Council Ref: DA205/15
(LD) (CIS)

15 December 2015

RE: SCECGS Redlands School Concept Proposal and Stage 1 Development
Your Ref: SSD 6454

North Sydney Council has reviewed the '*Response to Submissions*' provided by the Applicant and wish to make the following comments:

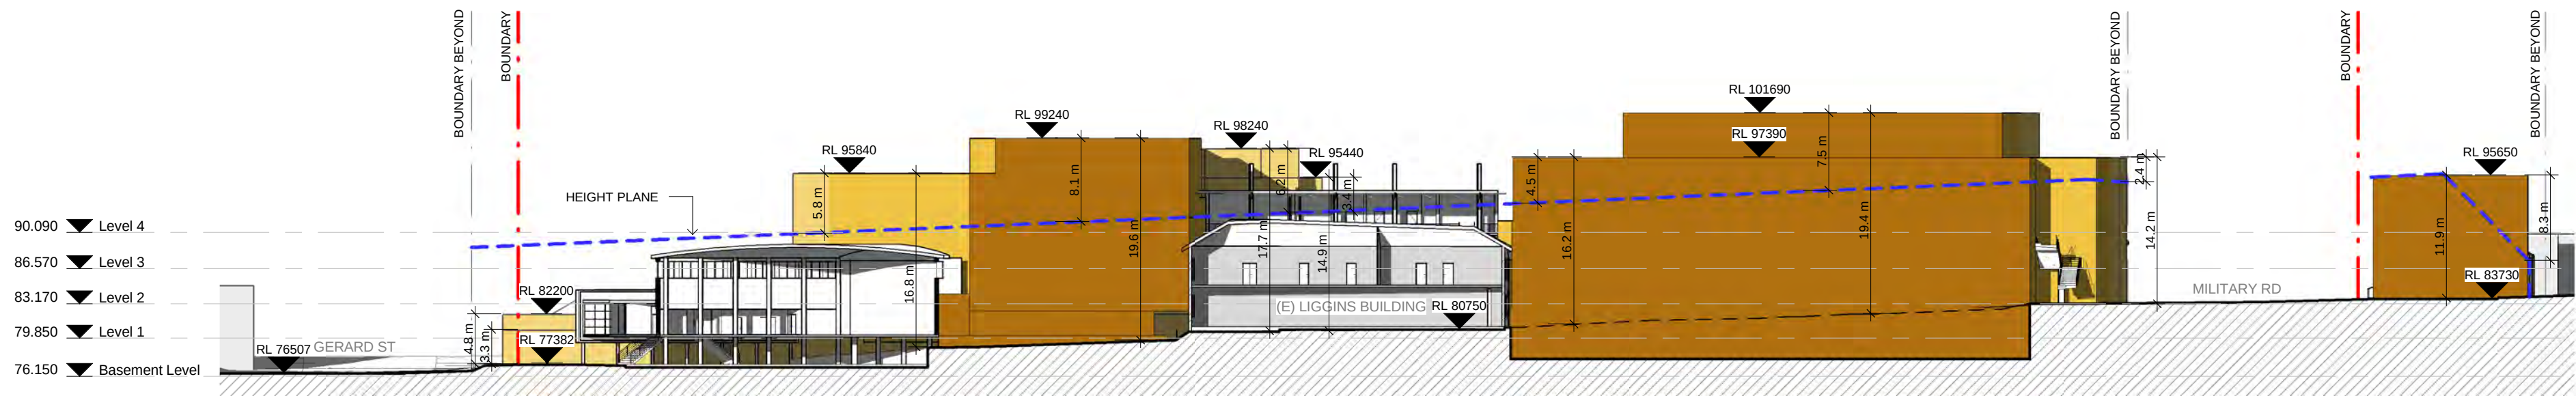
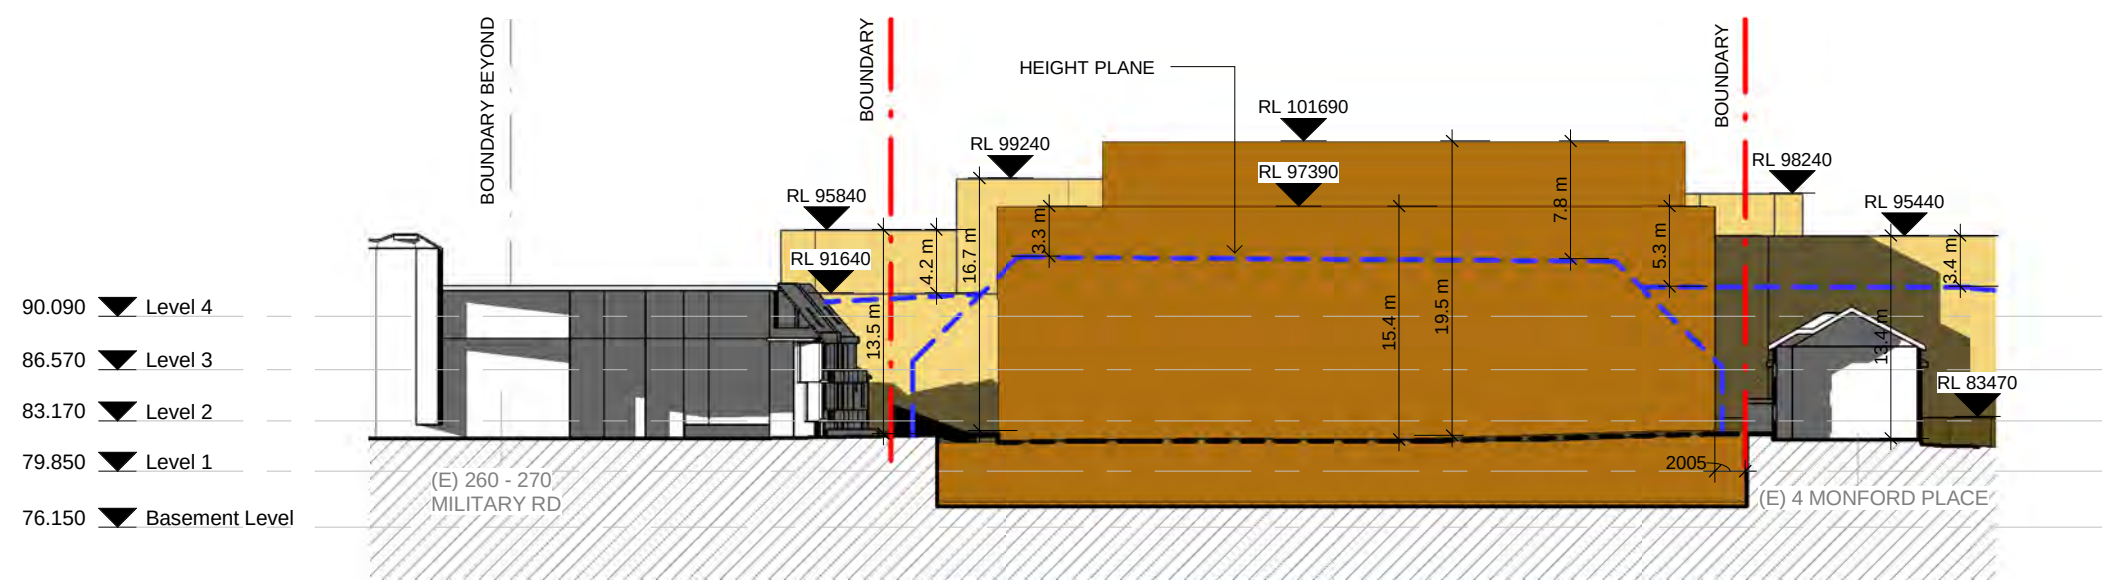
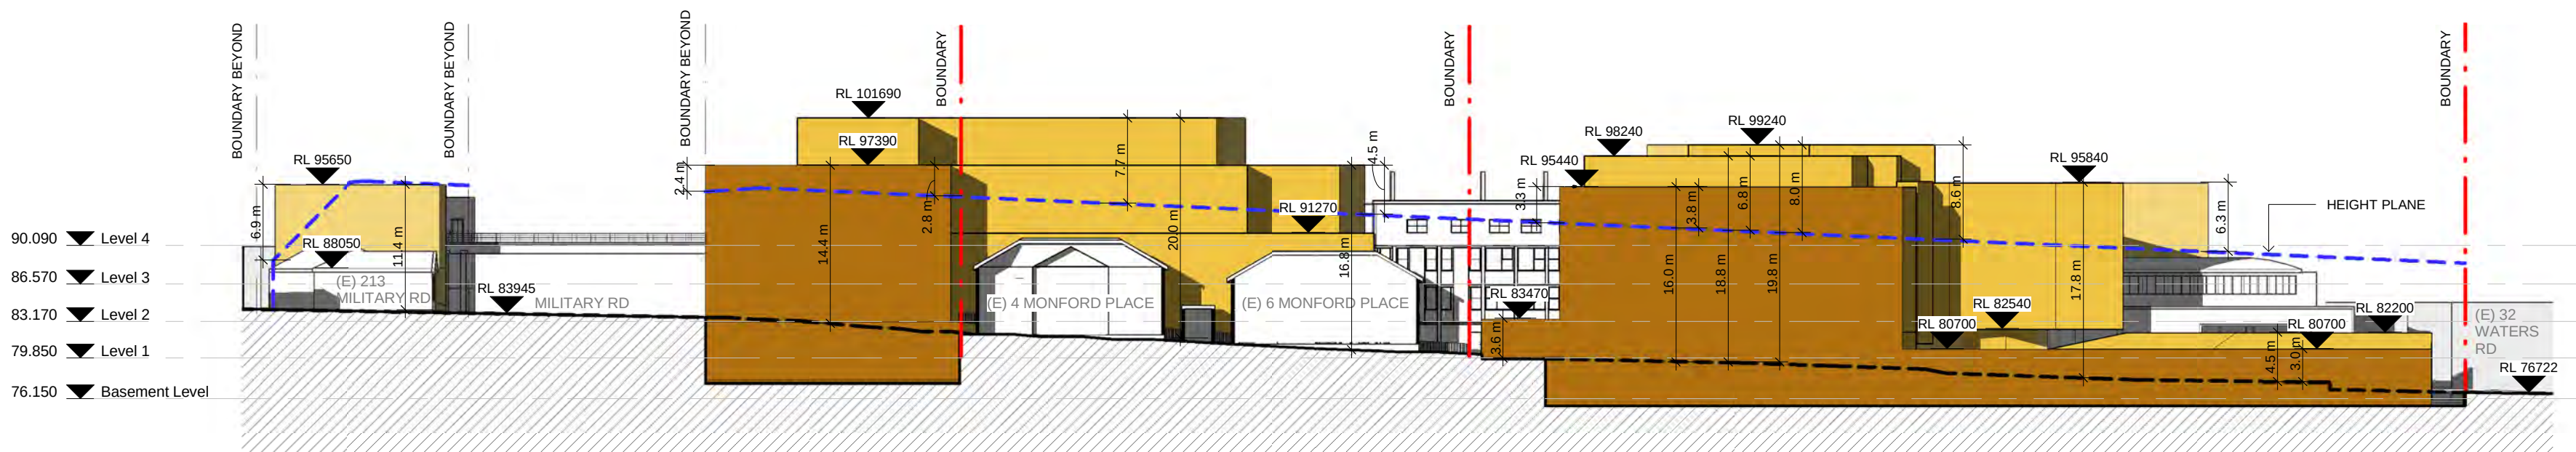
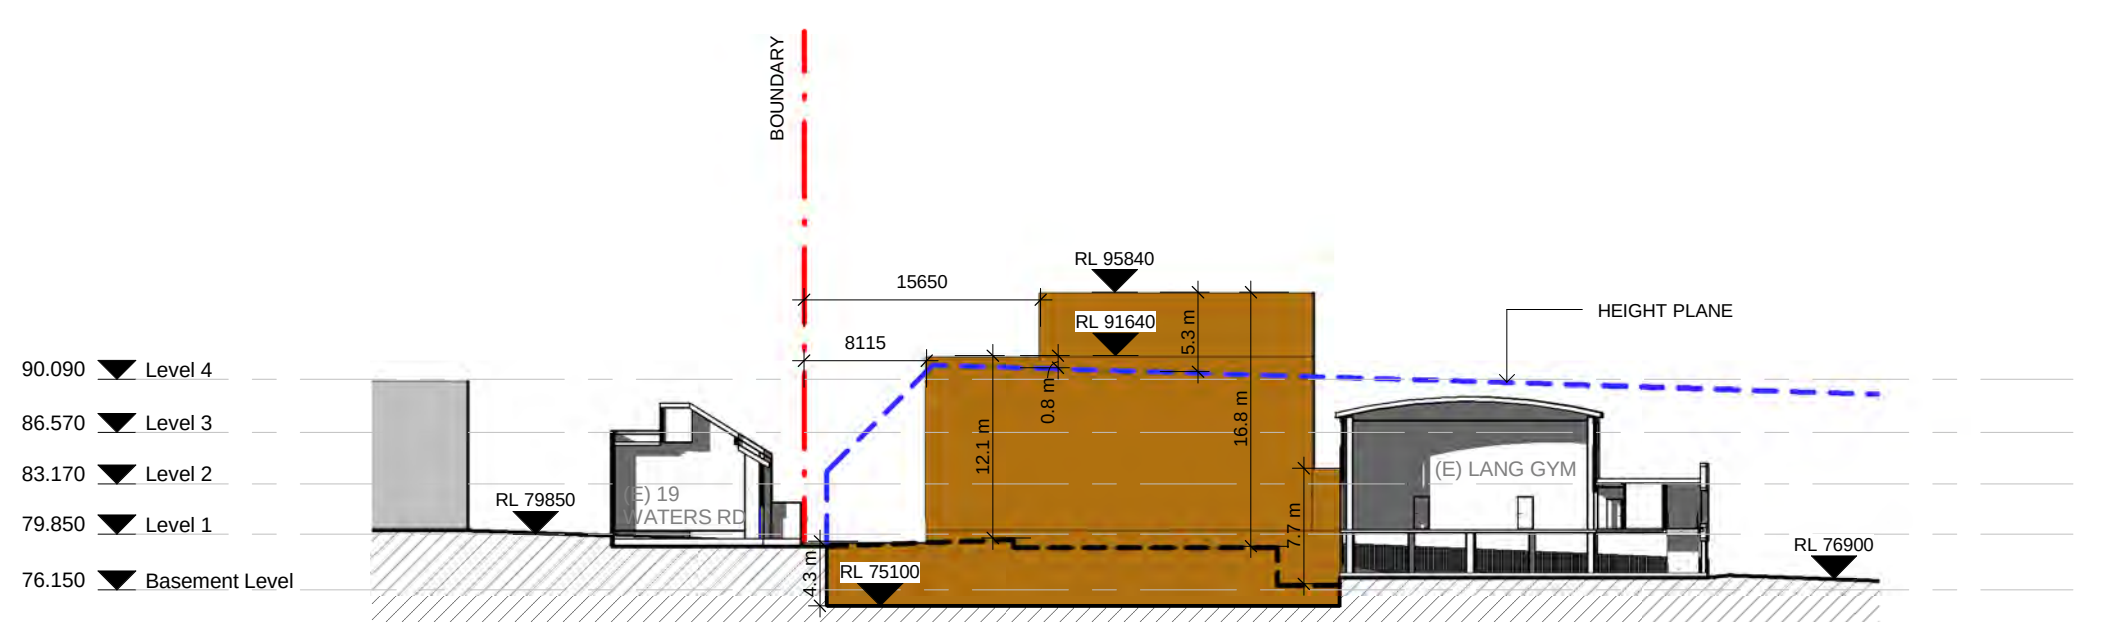
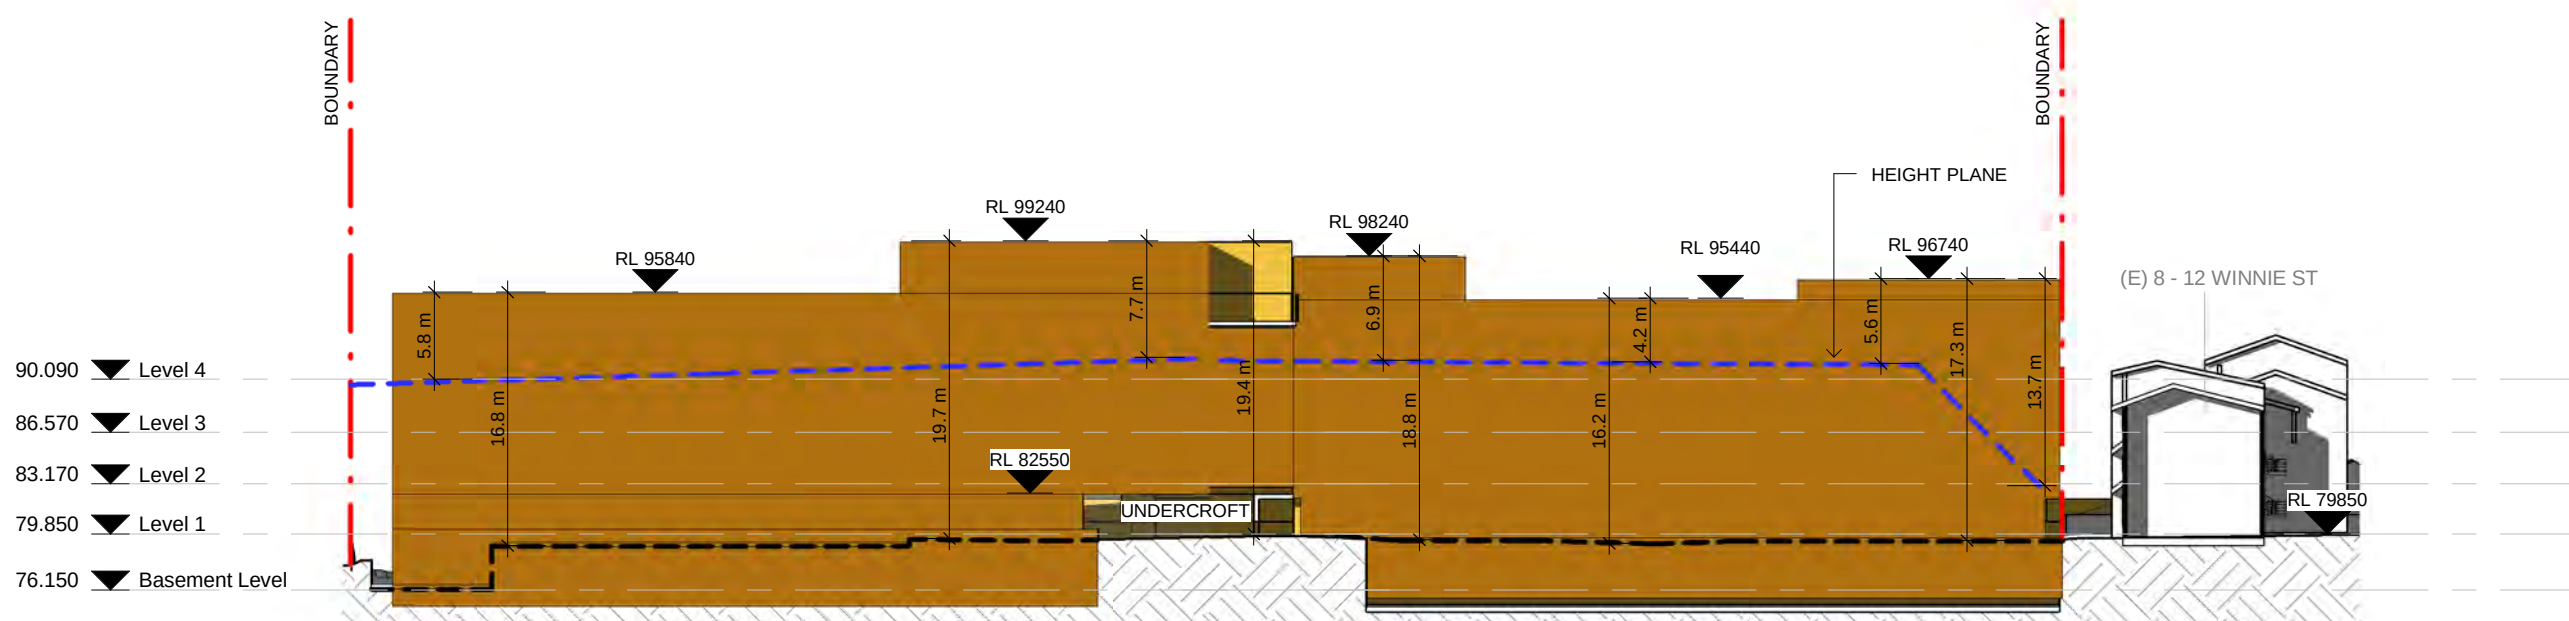
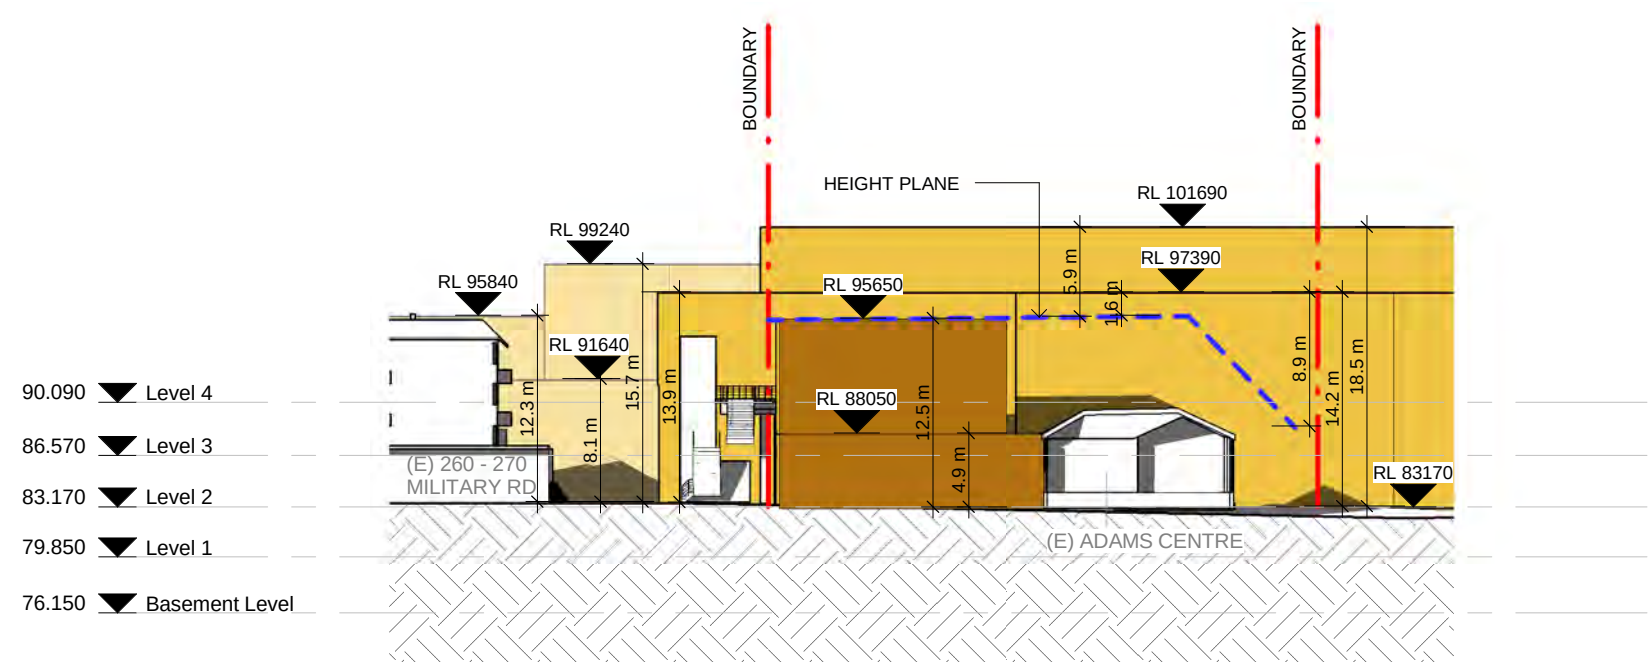
Clause 4.3(3) of NSLEP 2013 states that the maximum permitted building height on the site is 12 metres. North Sydney Council acknowledges that some amendments have been made to the building envelope and heights of the proposed New Sports Hall and Drama Building (Stage 2) and the New Humphreys Building (Stage 4). Notwithstanding, North Sydney Council is of the firm view that the scale of the New Humphreys Building (Stage 4) being a maximum of 22.4m is still incompatible with the sites adjoining and opposite along Waters Road that are zoned R4 High Density Residential with a maximum permissible building heights of 12m (**refer to Figures 1 and 2 below**).

The New Humphreys Building (Stage 4) is proposed at a building height of between 14.1m (RL91.64) and 22.4m (RL99.24) which is significantly higher than maximum building heights (12m) permissible on sites adjoining (No.19 Water Road) and opposite (No's 26, 28 and 30 Water Road).

The significant non compliances with the height control for this building is contrary to the Aim of Plan 1.2(2)(b)(i) and building height objectives 4.3(1)(c), (e) and (f) of NSLEP 2013 which seek to:

Such variations in height must be justified by a strategic level study which is absent here.

A further reduction in the scale of the New Humphreys Building (Stage 4) and a greater setback from the western boundary of the site would significantly improve solar access, particularly between the critical hours of 10.30am and 12noon during winter solstice, to the ground floor living rooms of the townhouses at No.19 Water Road.

The fencing around the proposed tennis courts on the roof of the New Sports Hall and Drama Building (Stage 2) will remain highly visible from Military Road (south western end) with a top of fence height (RL101.69) that is between 6.7m and 8.1m above the maximum height control. The sites to the west of the School have a maximum building height of 16metres. The top of the tennis court fence would be more than 3 metres above permissible height limit for surrounding development. The proposed height would not only be visible from the public domain but also incompatible with the desired built form, massing and scale of the Waters Neighbourhood Character Statement as detailed in Part C, Section 5.2.3 in NSDCP 2013.

Figure 22: Access Location Stage 1 – Stage 3

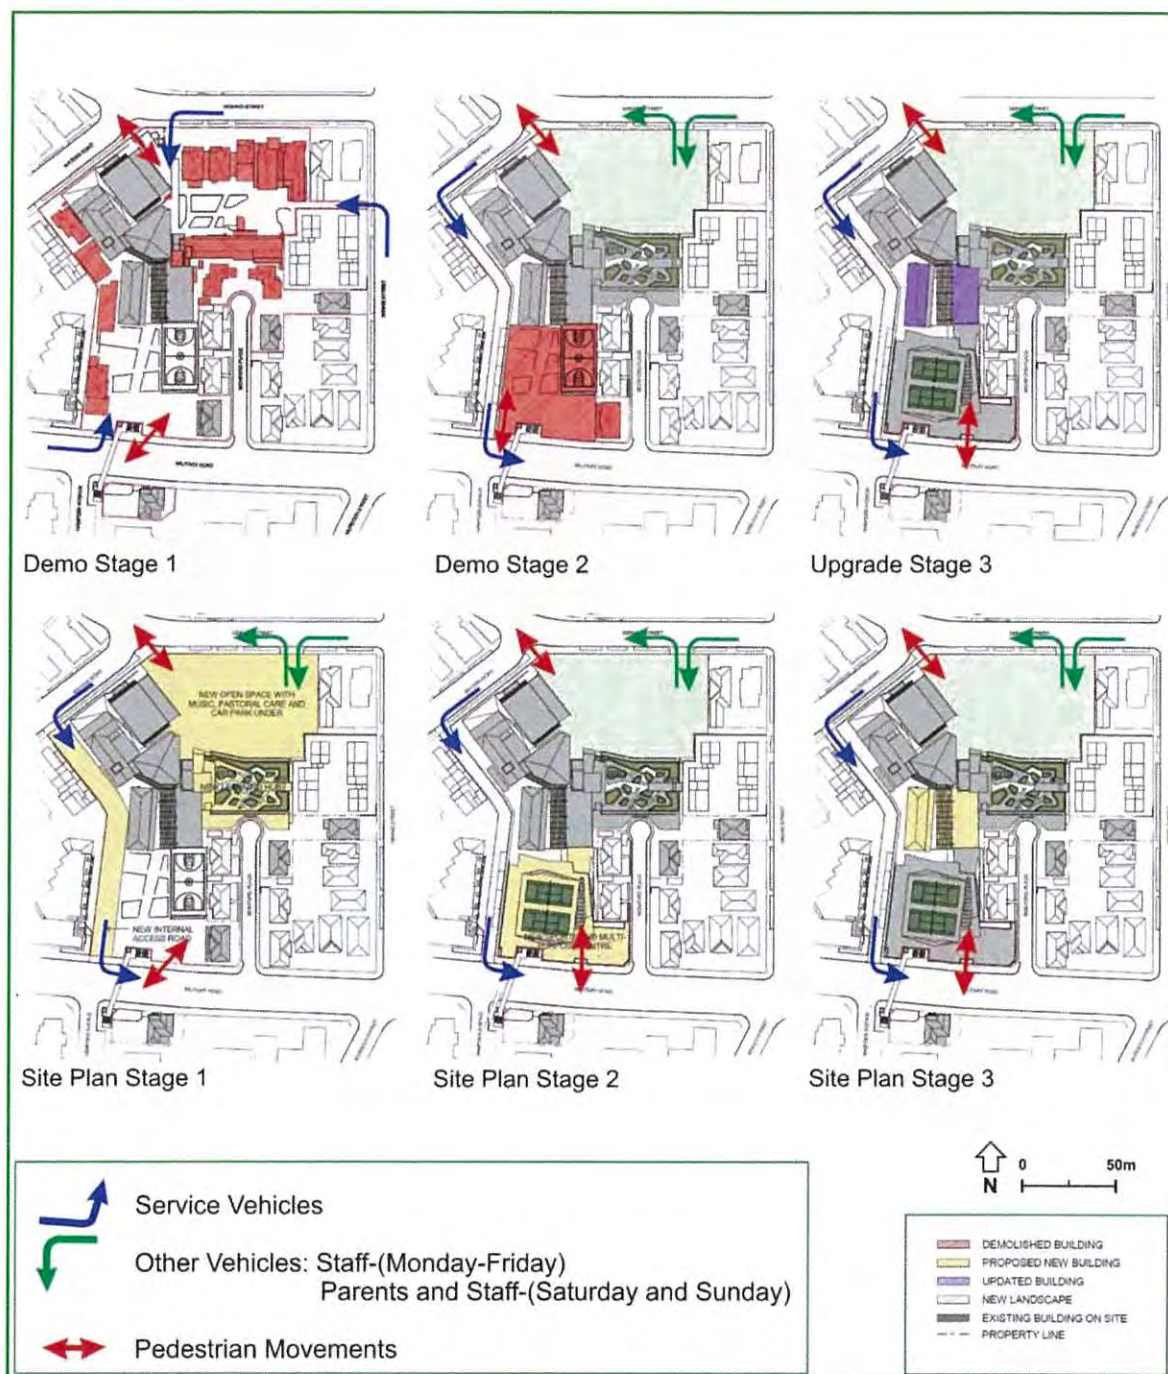
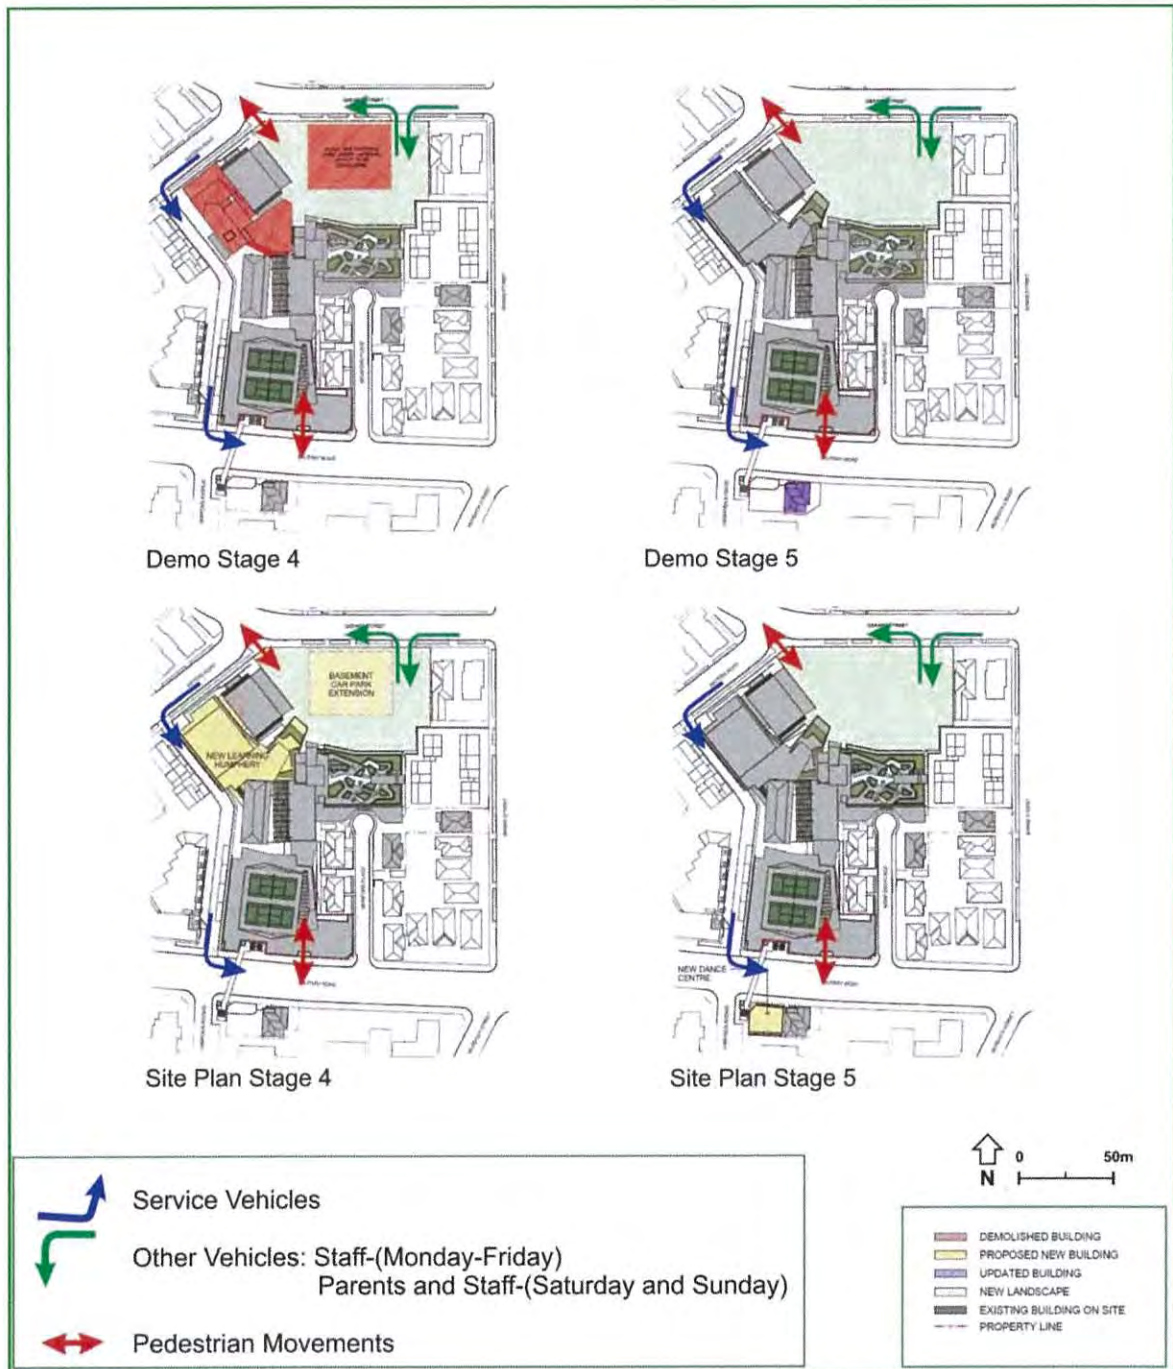
The carpark is proposed to be reduced to 92 parking spaces. The proposed driveway width on Gerard Street has been reduced from 12m to 9.3m. Wide vehicular crossings increase the length of the crossing for pedestrians which increases the area of conflict. Traffic flows are likely to be predominantly one way in during the morning peak and out in the afternoon. It is recommended that the driveway width be reduced to 6m, the standard width for a double width vehicle crossing and adequate for the anticipated traffic flow.

‘No right turn’ signage on its own is unlikely to prevent vehicles entering and exiting the driveway from the right. If the vehicle crossing is approved it is recommended that a median strip should be installed to restrict entry and exit to left-in, left-out to reduce turning conflicts and reduce conflicts with pedestrians, subject to Traffic Committee approval.
